Tenant Name: Fabletics

Property Name: ABQ Uptown

Preliminary Review: Approved As Noted

DESIGN PACKAGE

BLADE SIGN REFERENCE

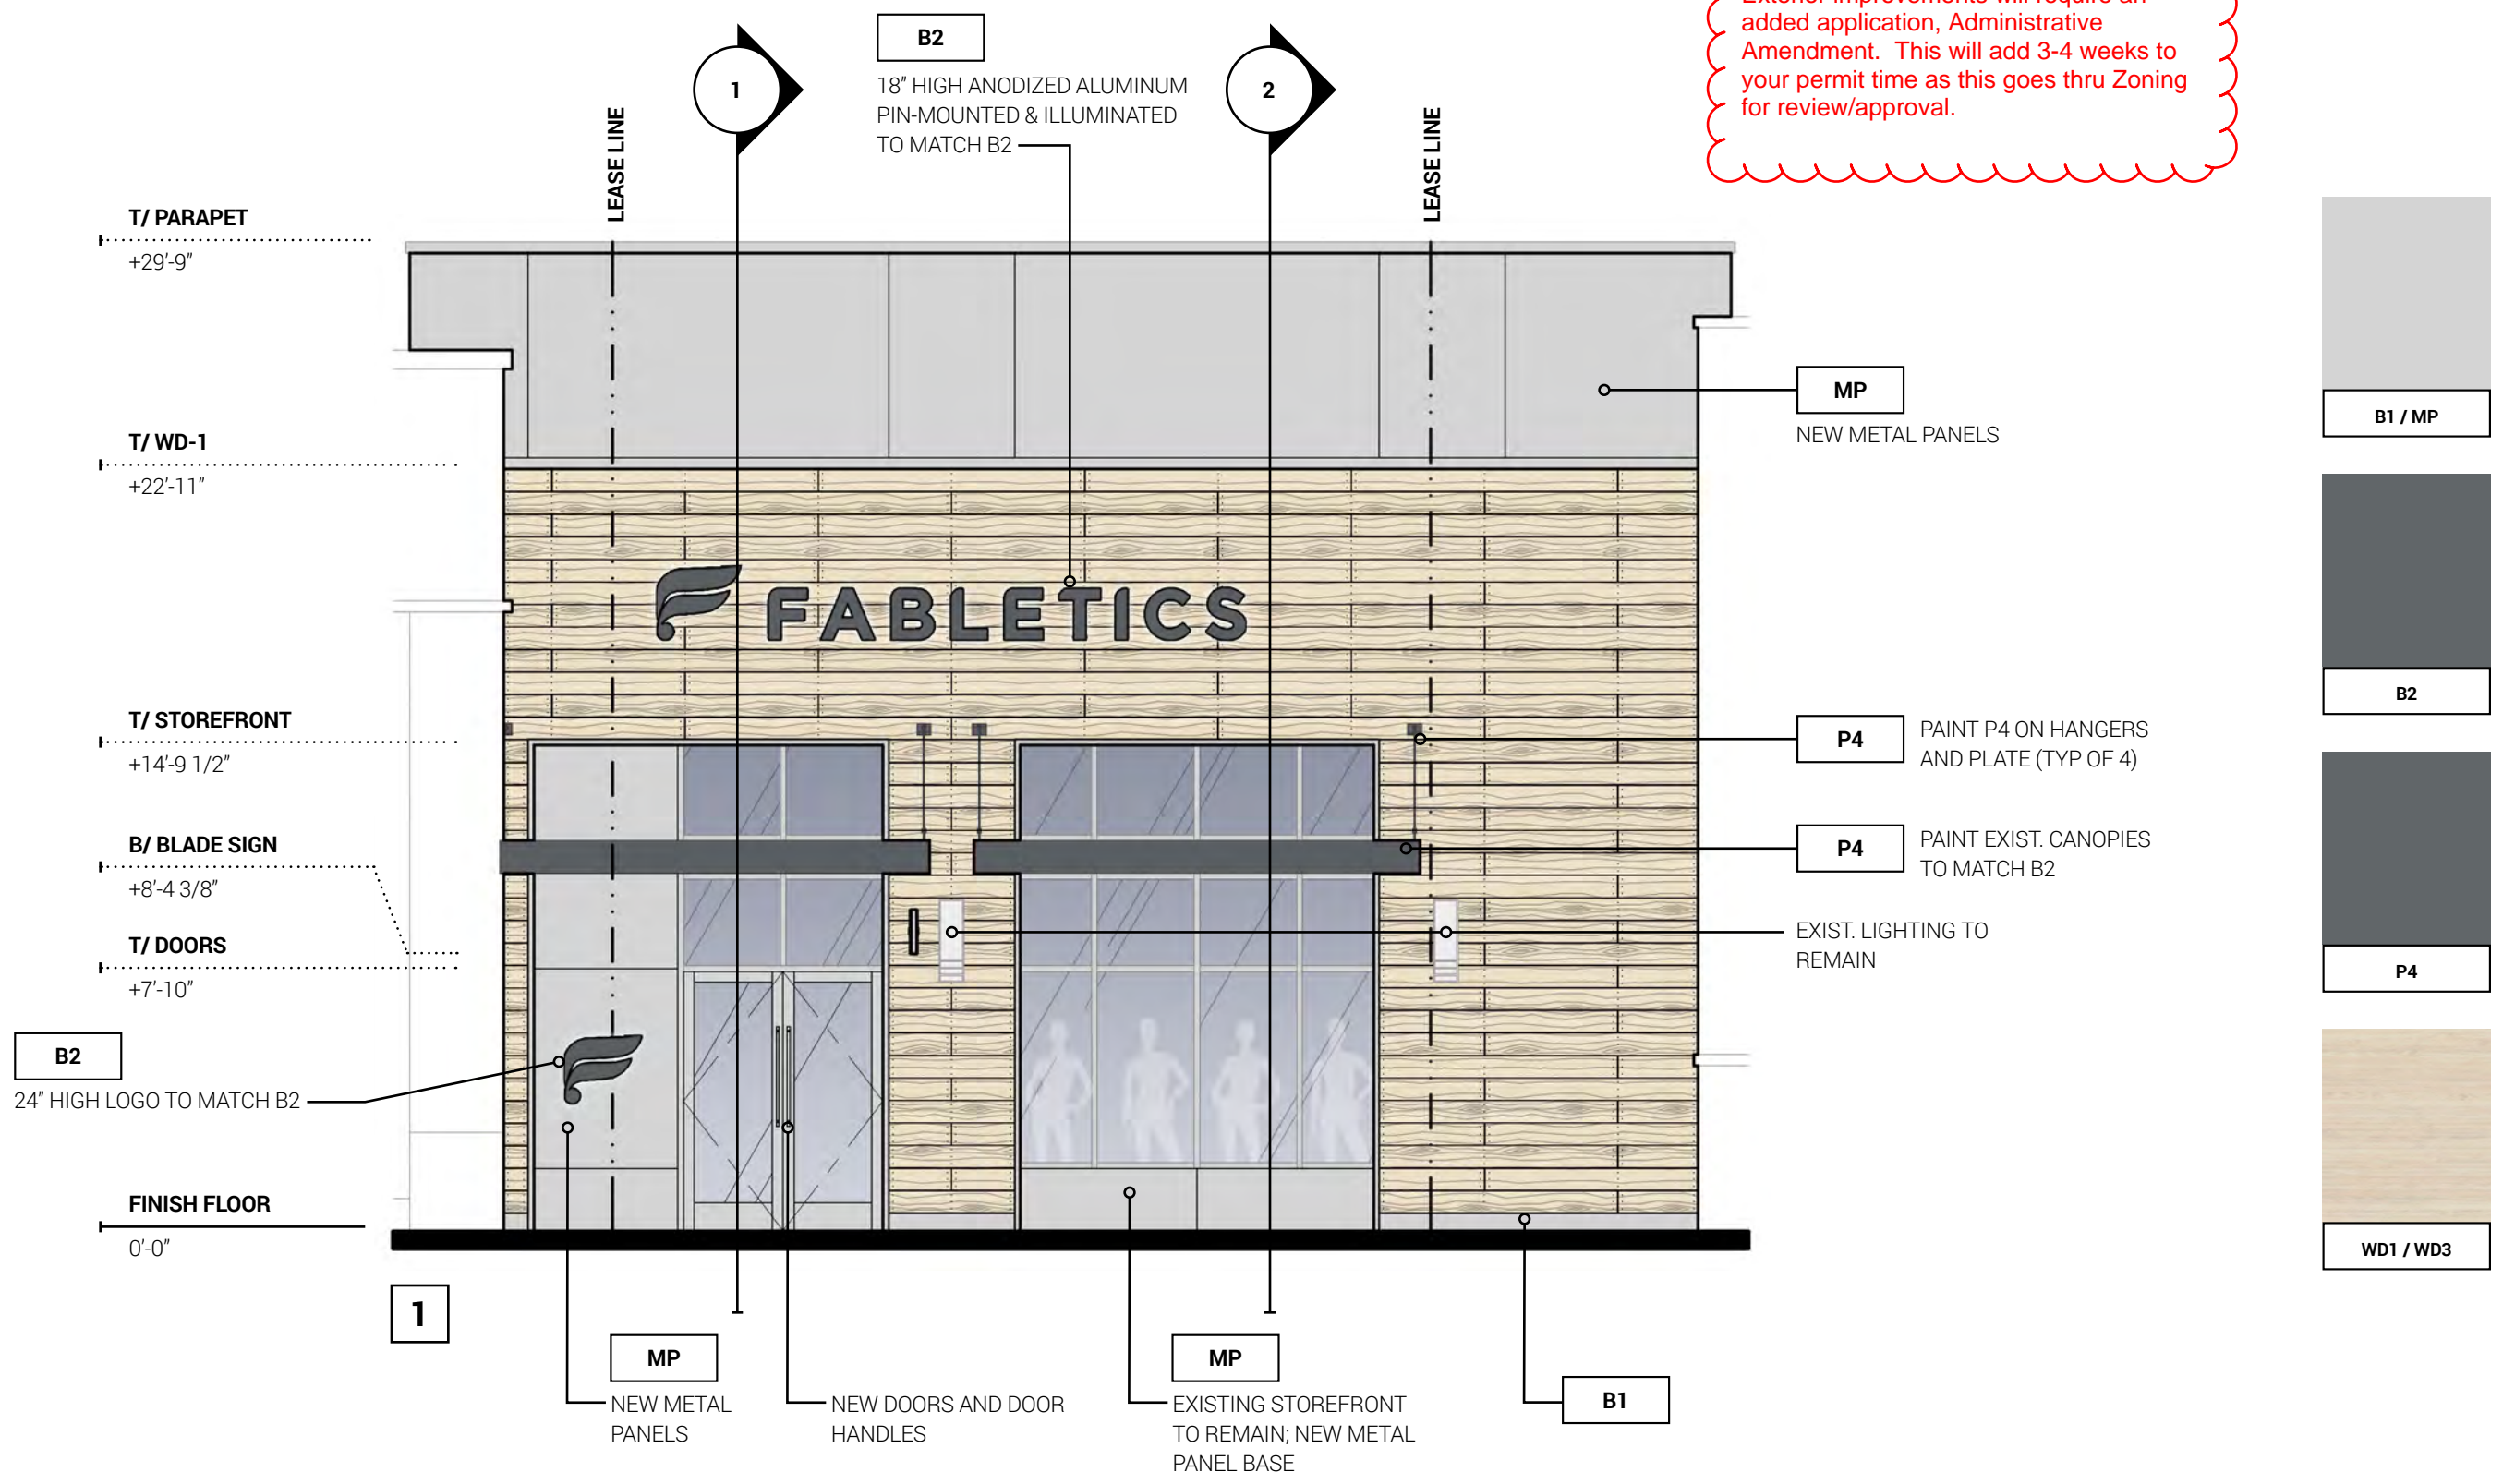
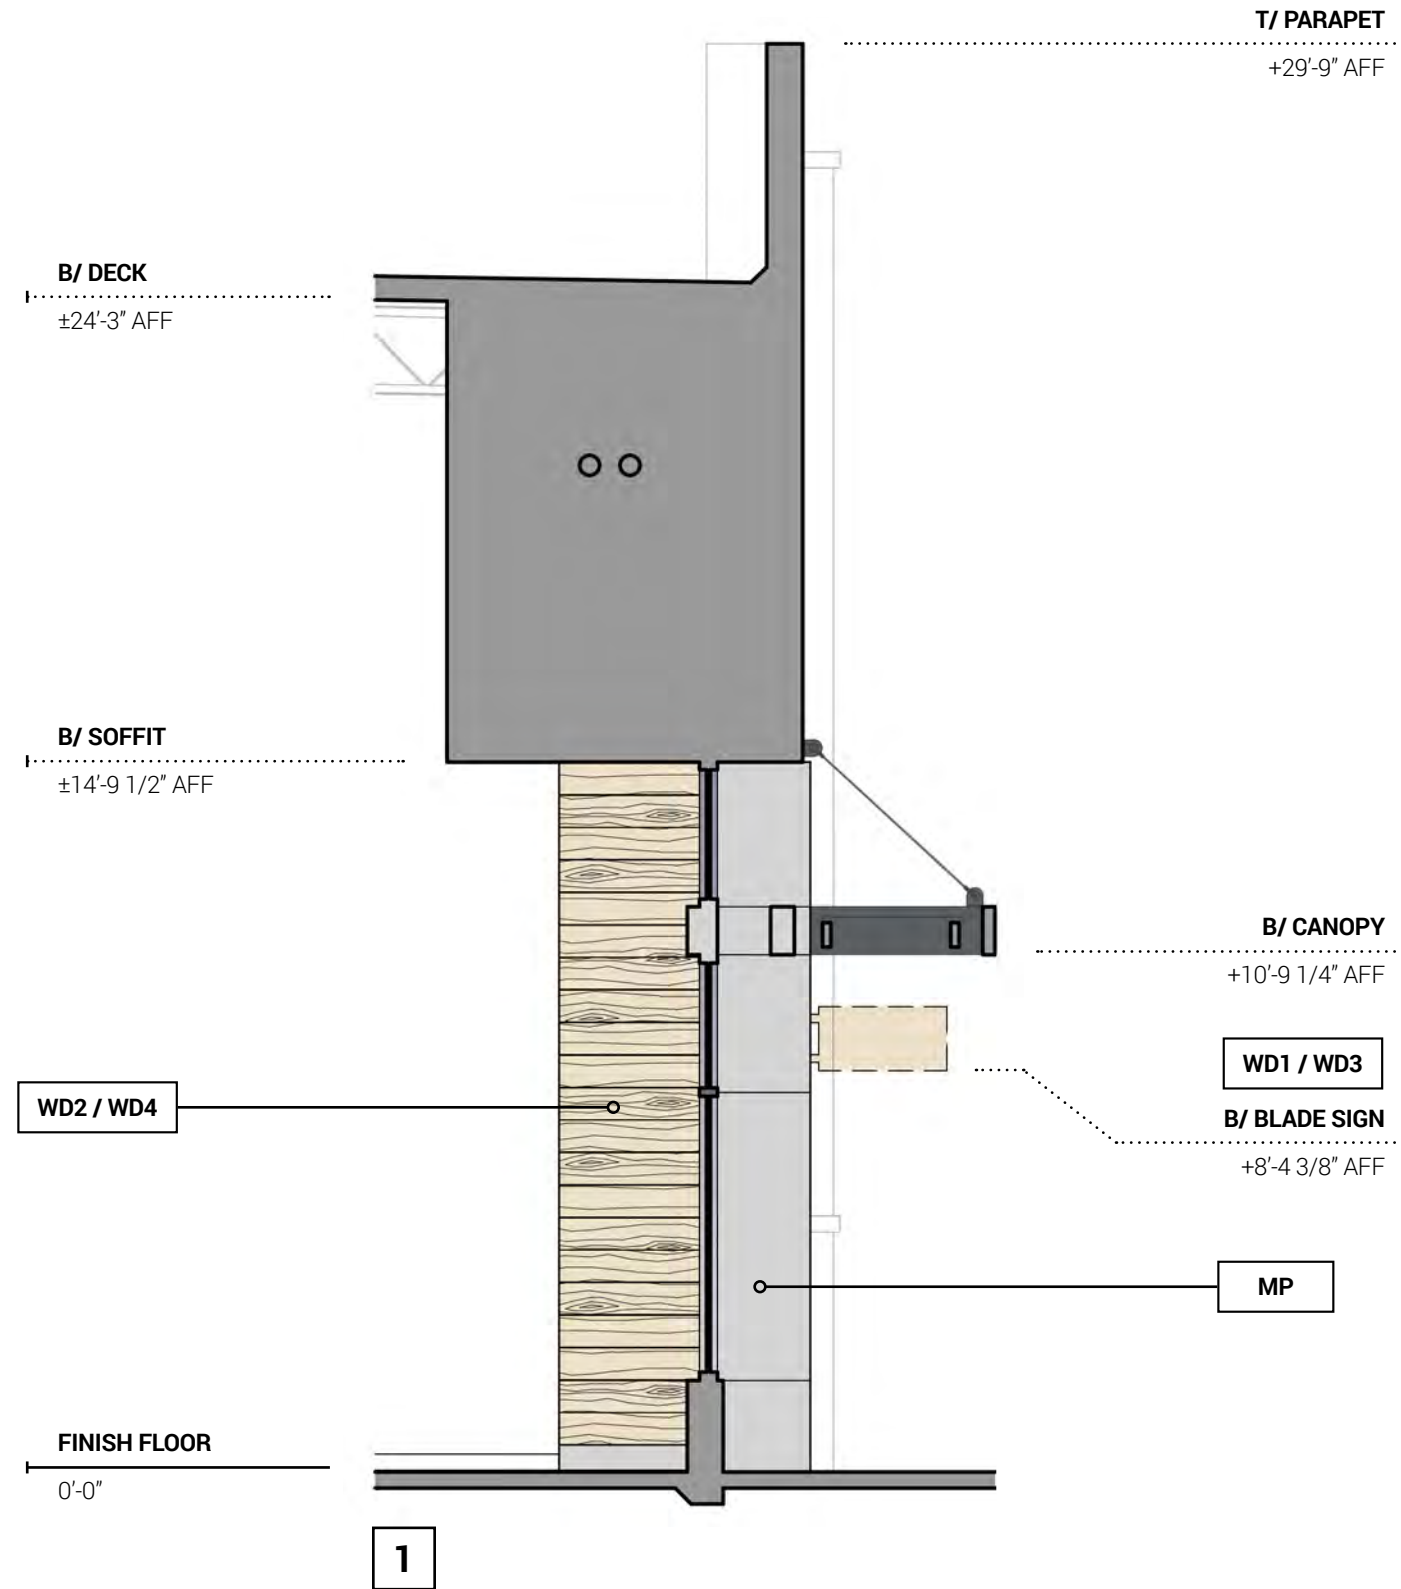
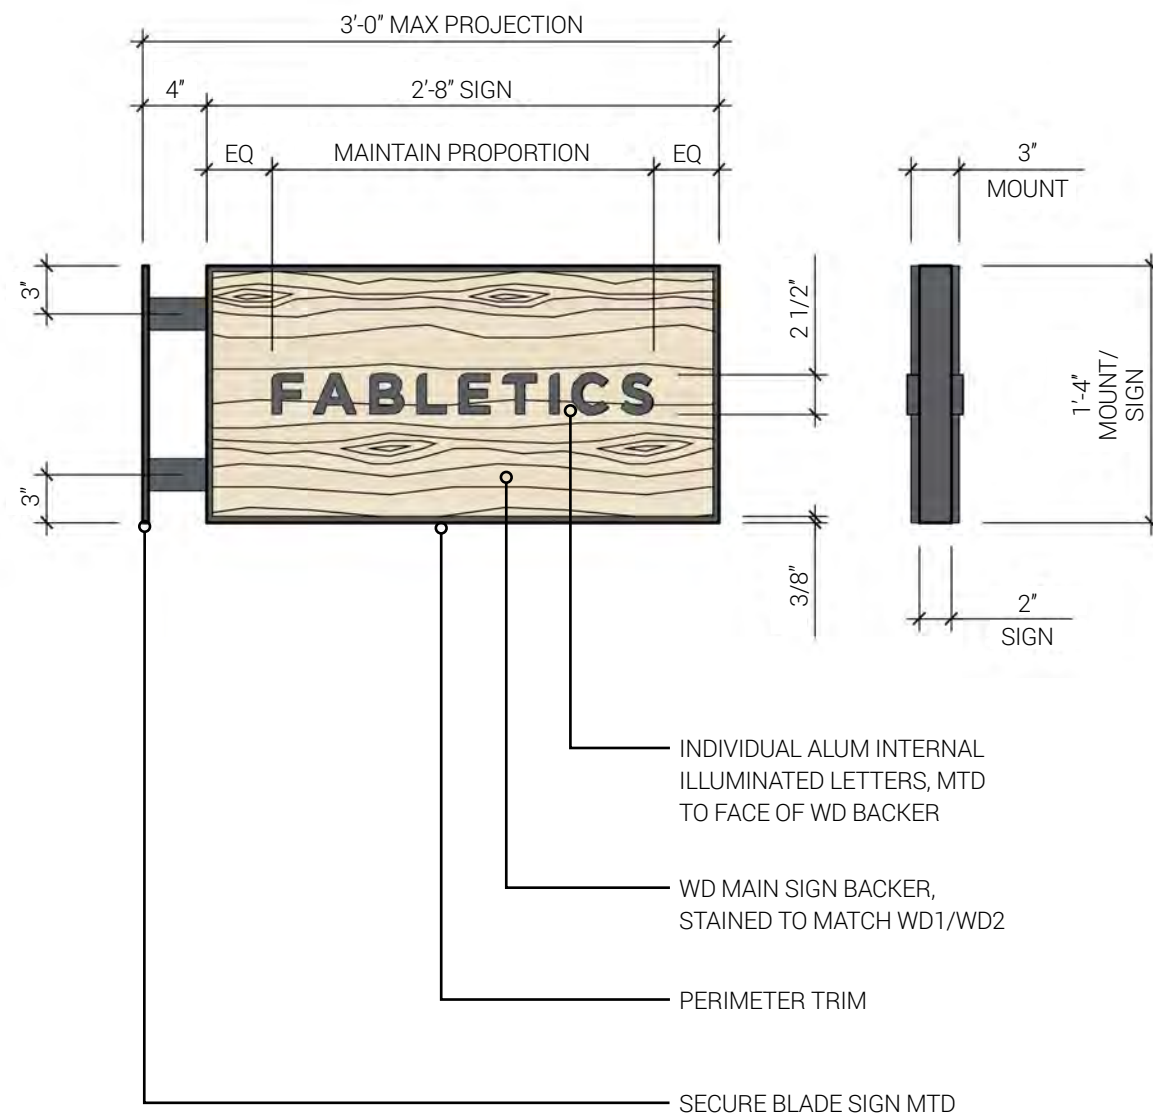
LL Comment (CMS):
 Exterior improvements will require an added application, Administrative Amendment. This will add 3-4 weeks to your permit time as this goes thru Zoning for review/approval.
